Application Ref:	2025/0783			 Ribble Valley Borough Council www.ribblevalley.gov.uk
Date Inspected:	12/12/2025	Site Notice:	N/A	
Officer:	EP			
DELEGATED ITEM FILE REPORT:				APPROVAL

Development Description:	Proposed two storey extension to rear of property to create additional living accommodation.
Site Address/Location:	2 Cherry Tree Road Whalley BB7 9YH.

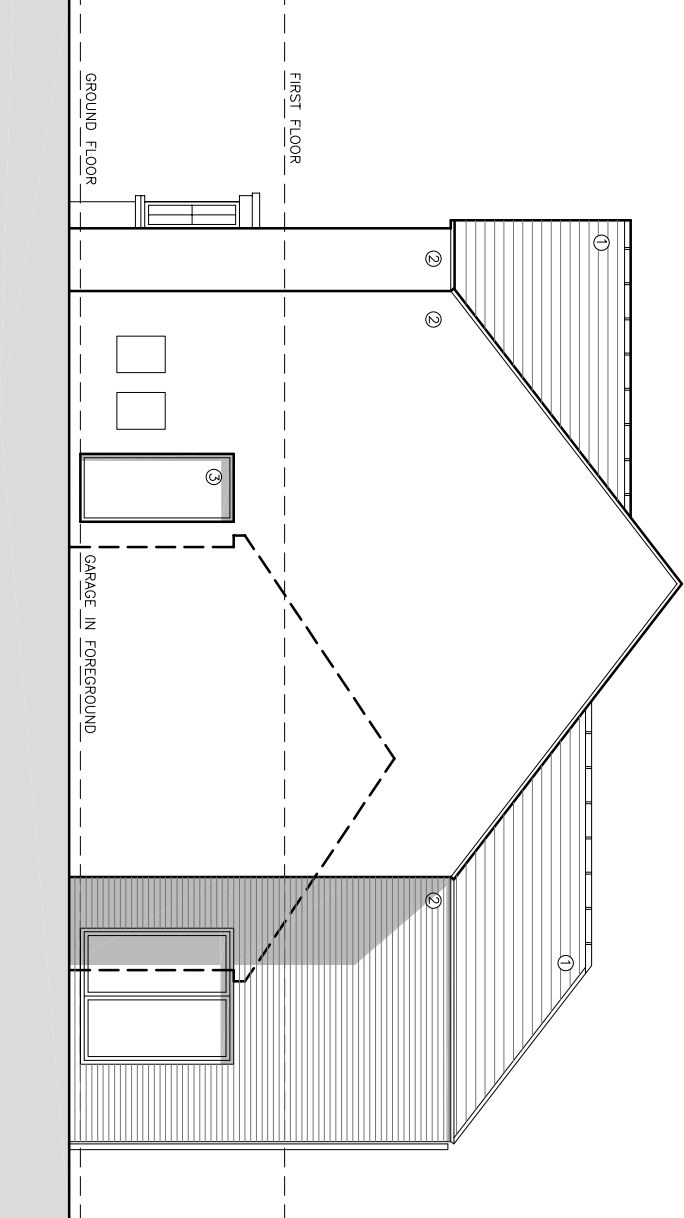
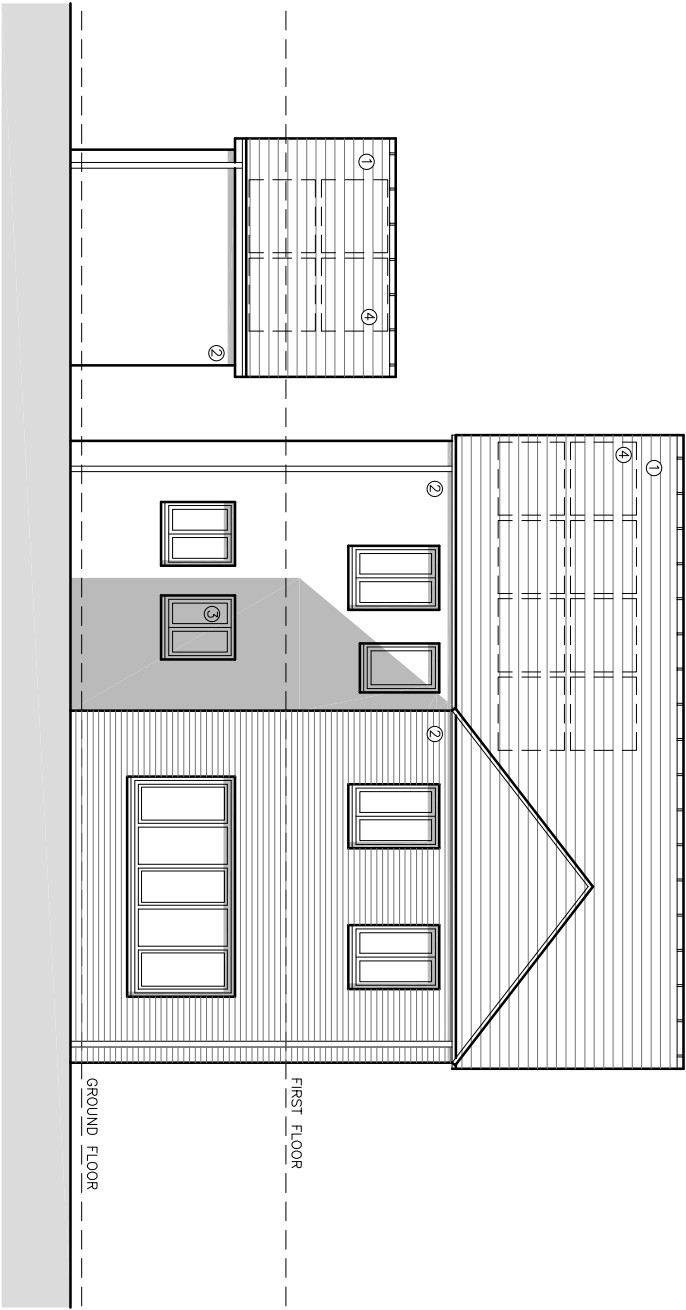
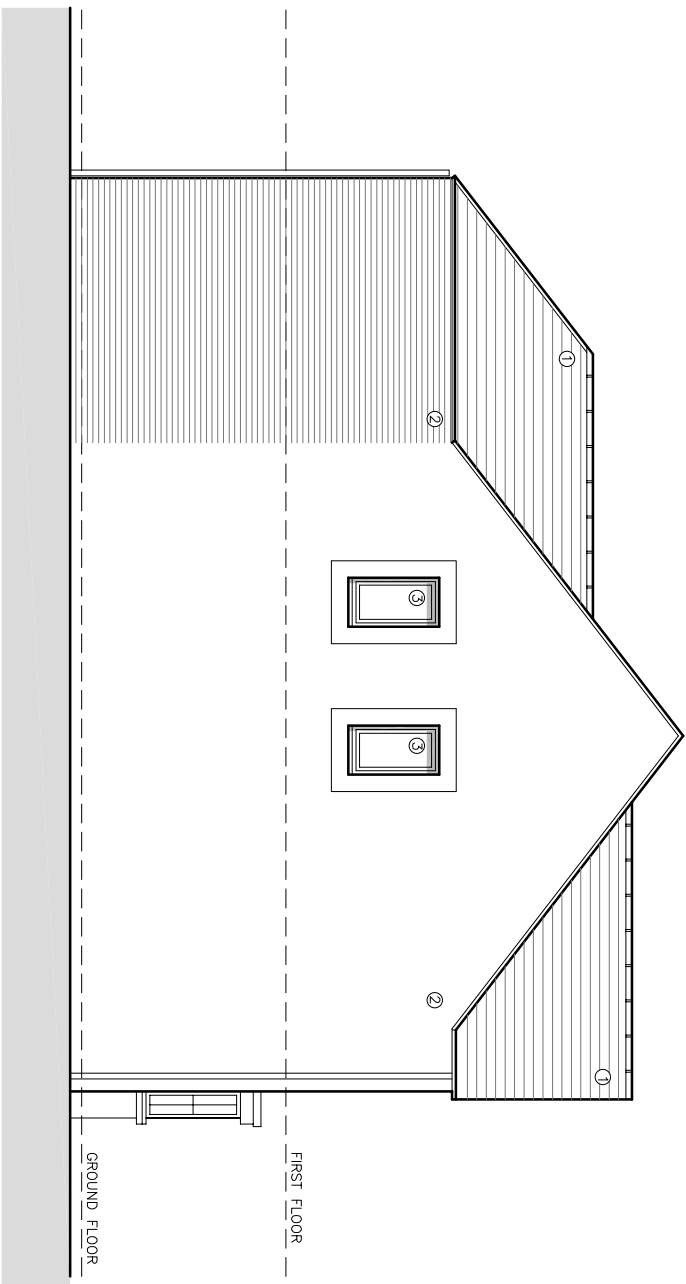
The proposed development is located at the rear of the application site and as a result will not host a visually prominent position within the street scene. Nonetheless, the proposed footprint is considered modest when read in relation to the host dwelling, measuring 4.6m by 3.5m in width and length. The ridge of the proposed extension will fall well below that of the existing dwelling and as result will remain entirely subservient.

In respect of materials, the proposed extension will be constructed in facing brickwork to the elevations, natural blue slate roofing and uPVC windows and doors. This is consistent with the application dwelling and properties in the vicinity and will consequently integrate sufficiently.

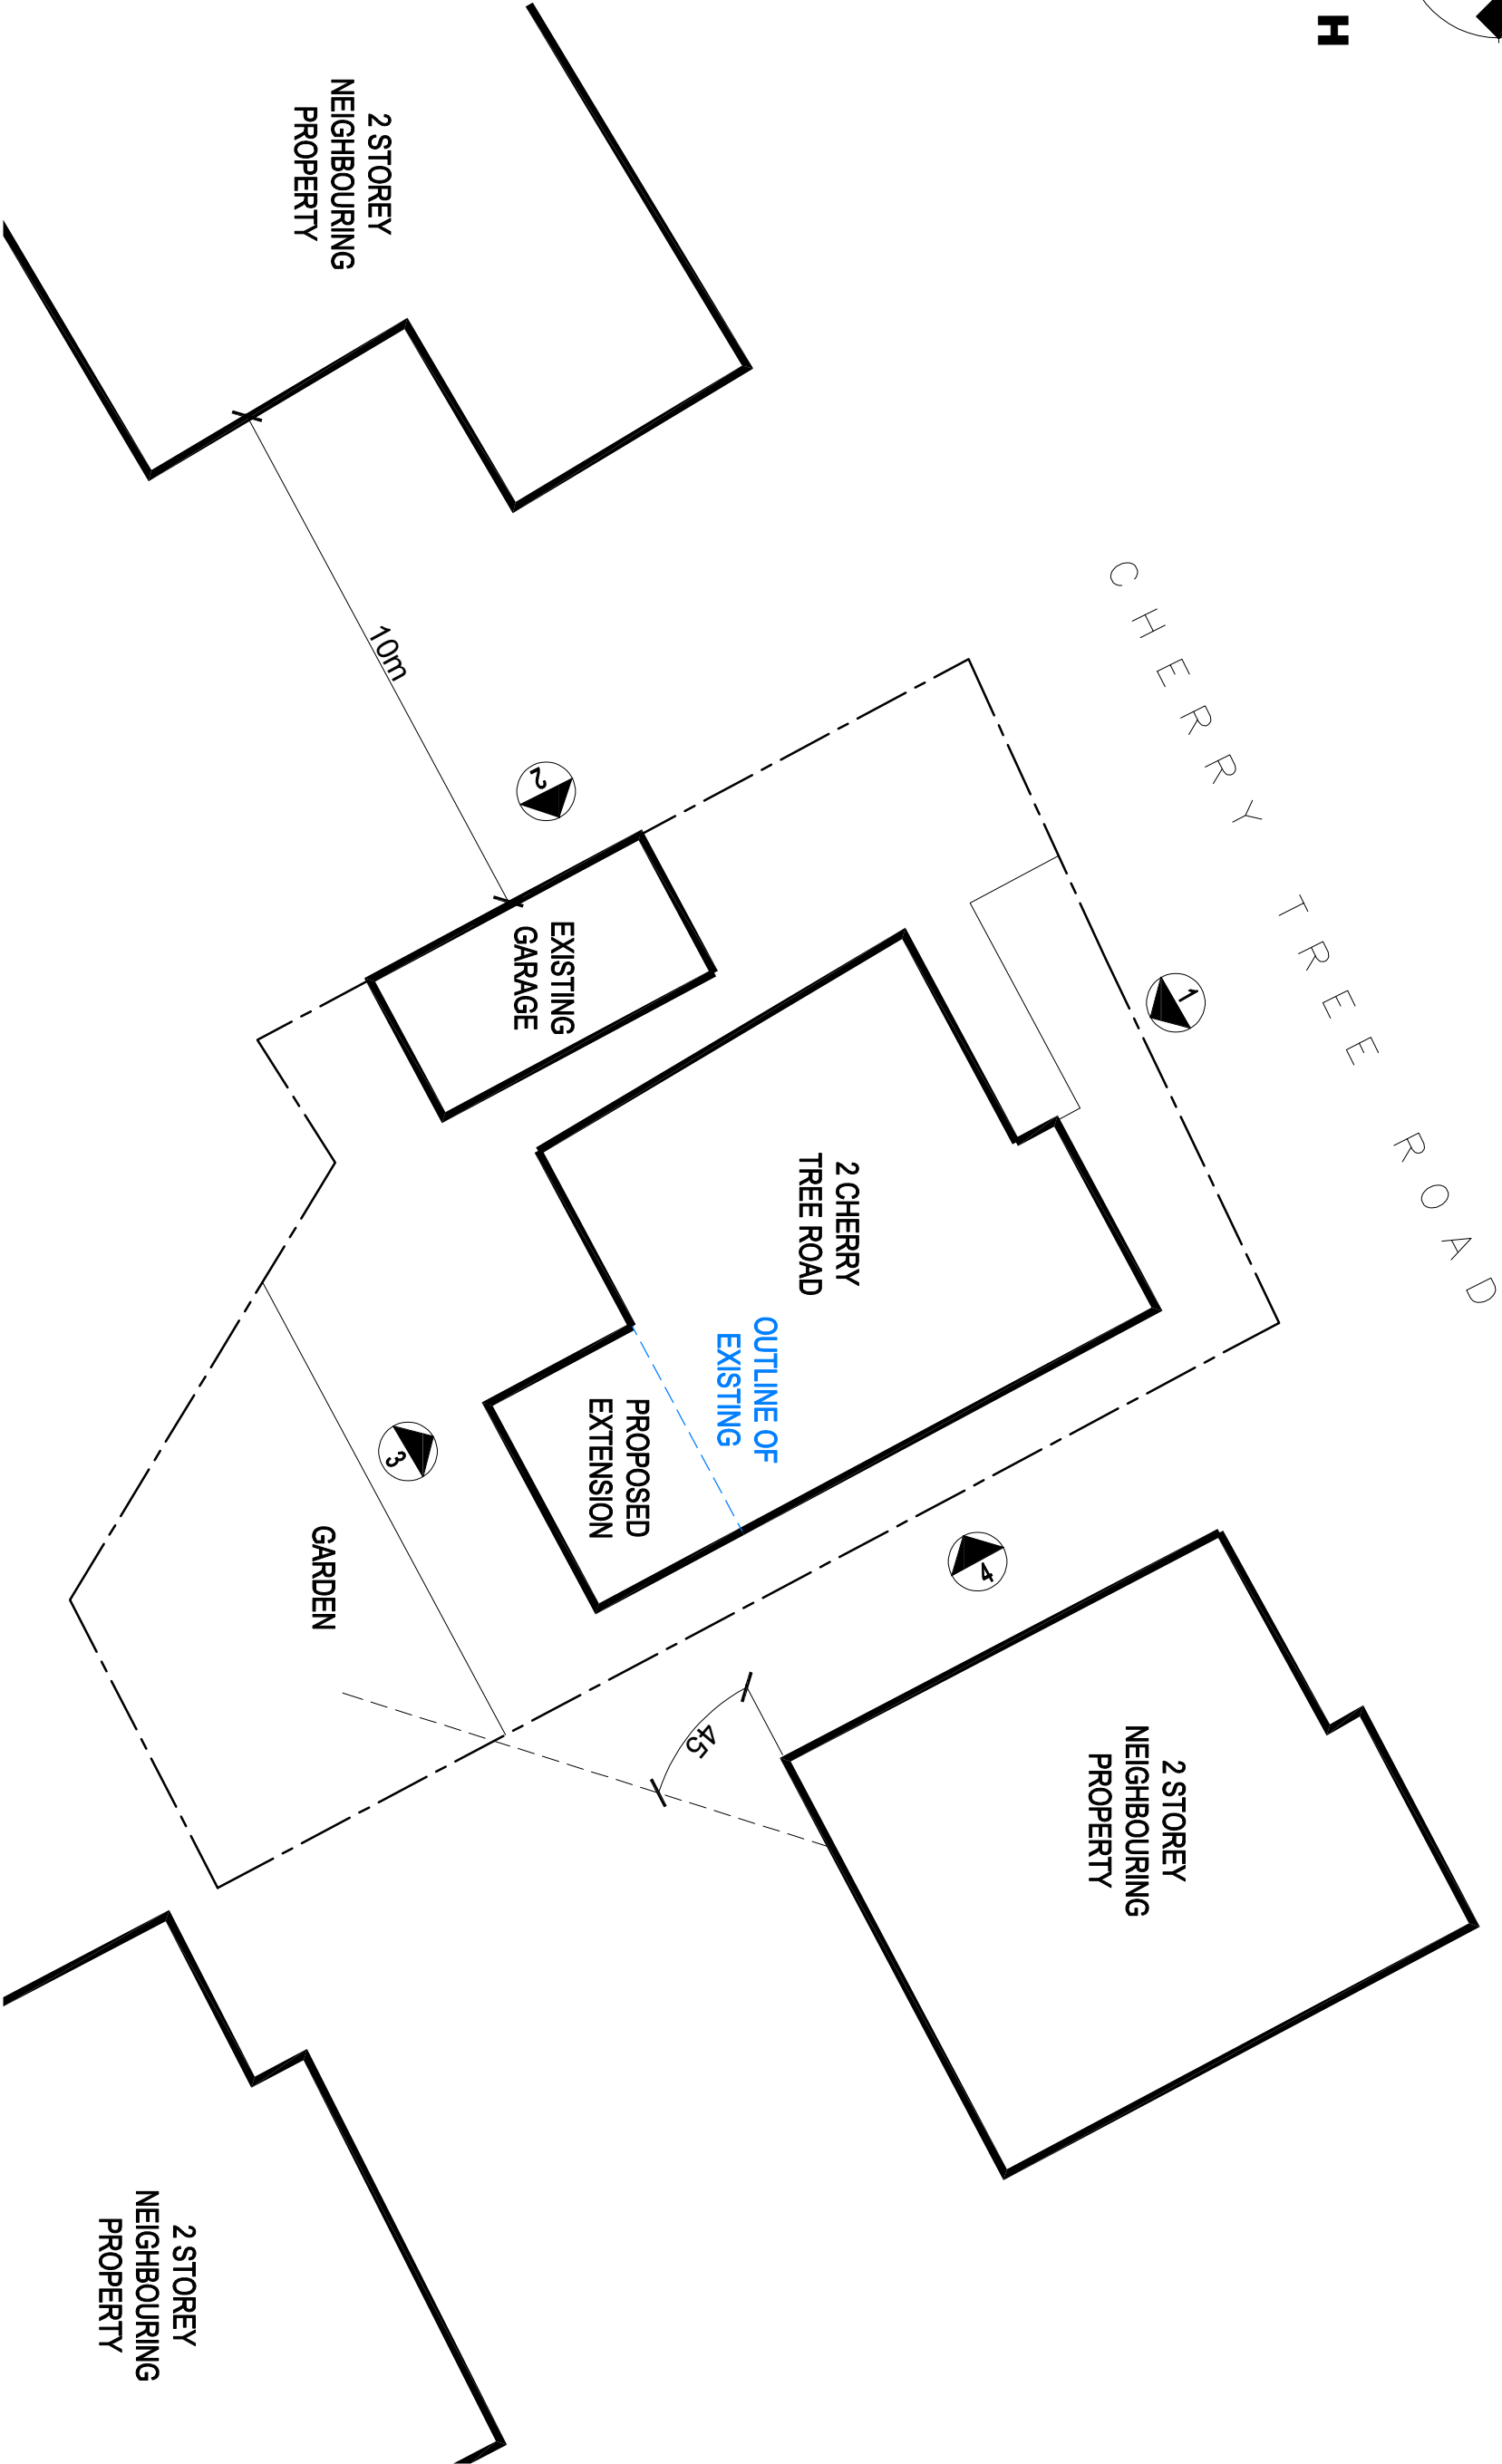
The application dwelling has several adjacent neighbours to the side and rear known as No.1 and No.3 River Way, No.8 Chew Mill Way and No.4 Cherry Tree Close. The proposed rear extension is located at the eastern side of the rear elevation and therefore is a sufficient distance from the receptors at River Close to mitigate any significant adverse impact.

No.4 Cherry Tree Road is located immediately to the east of the application site with the proposed development being erected in close proximity to the adjoining shared boundary. The submitted plans demonstrate that the development would not contravene the 45-degree angle test in relation to light to neighbouring habitable windows and as such there are no concerns in respect of loss of light. The neighbouring garage structure is located along the shared boundary which will provide a level of screening of the development at ground floor level and from within the neighbouring garden. Based on the above and taking into consideration the modest 3.5m rearwards projection of the development, there are no adverse impacts expected for the neighbouring property to the east.

No.8 Chew Mill Way is located at the rear of the application site. Desktop analysis shows that there is a sufficient distance of approximately 7.5m between the proposed development and the neighbouring boundary to mitigate any sense of overbearing. It is recognised that concerns have been raised in regard to potential overlooking and loss of privacy for neighbouring receptors resultant of the windows in the rear elevation of the extension. However, 7.5m from the boundary is a reasonable distance to mitigate any potential overlooking. No. 8 does not have any windows to the rear reducing the potential for overlooking and loss of privacy internally. Furthermore, the windows are located in a similar position with the existing rear elevation of the dwelling. The existing windows already allow for a degree of overlooking into neighbouring curtilage. As no. 8 does not have any windows to the rear the proposal would not result in any greater impact than when compared to the existing arrangement.
